Application Ref: H14-0049-24

Proposal: **Extension to existing unit for manufacturing facilities and new storage outbuilding including material changes to external facade of existing unit and internal changes**

Location: **Glen Farrow Limited, Glendum Close, Pinchbeck, PE11 3DQ**

ADDITIONAL INFORMATION REQUIRED

**Proposed Site Plan 1:500**

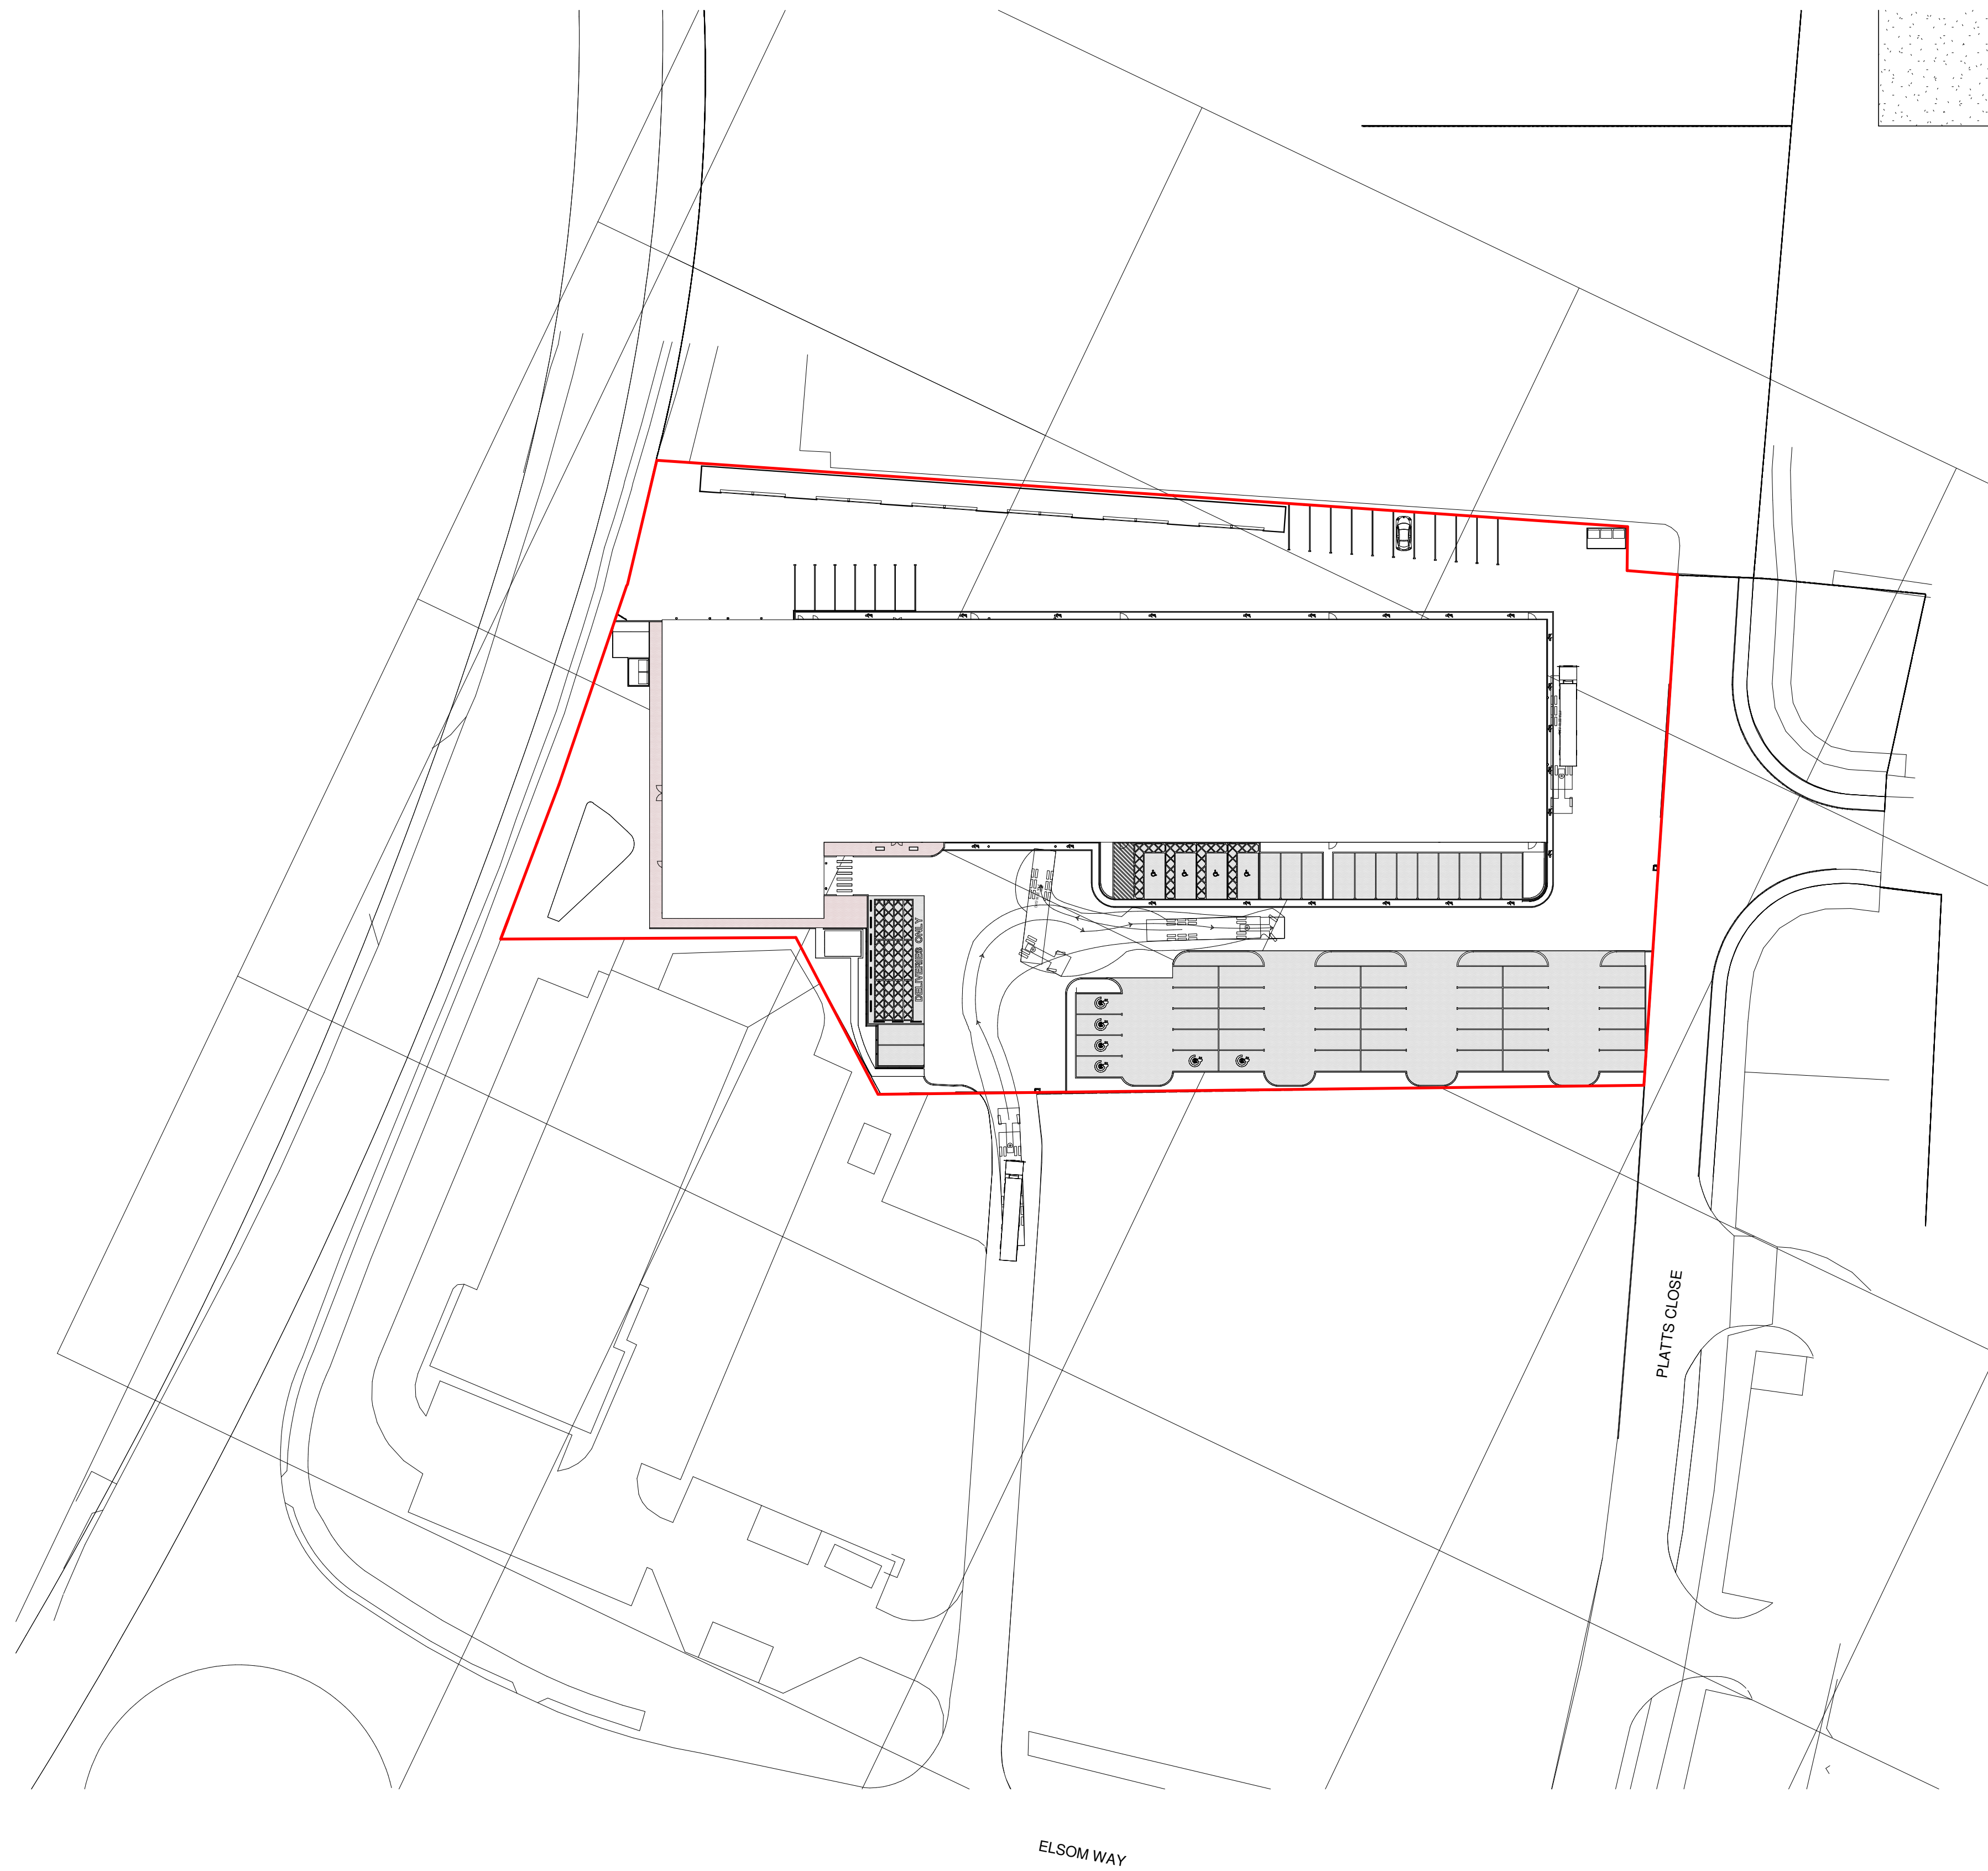
Secure, covered bicycle storage is required for visitors/staff and should be located close to the main entrance to the building.

The Design and Access Statement says there are two entry points to the site but yet the proposed block plan only shows one from Elsom Way. I understand the second access is from Platts Close. A pedestrian entrance is also referred to from the B1180 - all access points need to be clearly detailed on the proposed block plan.
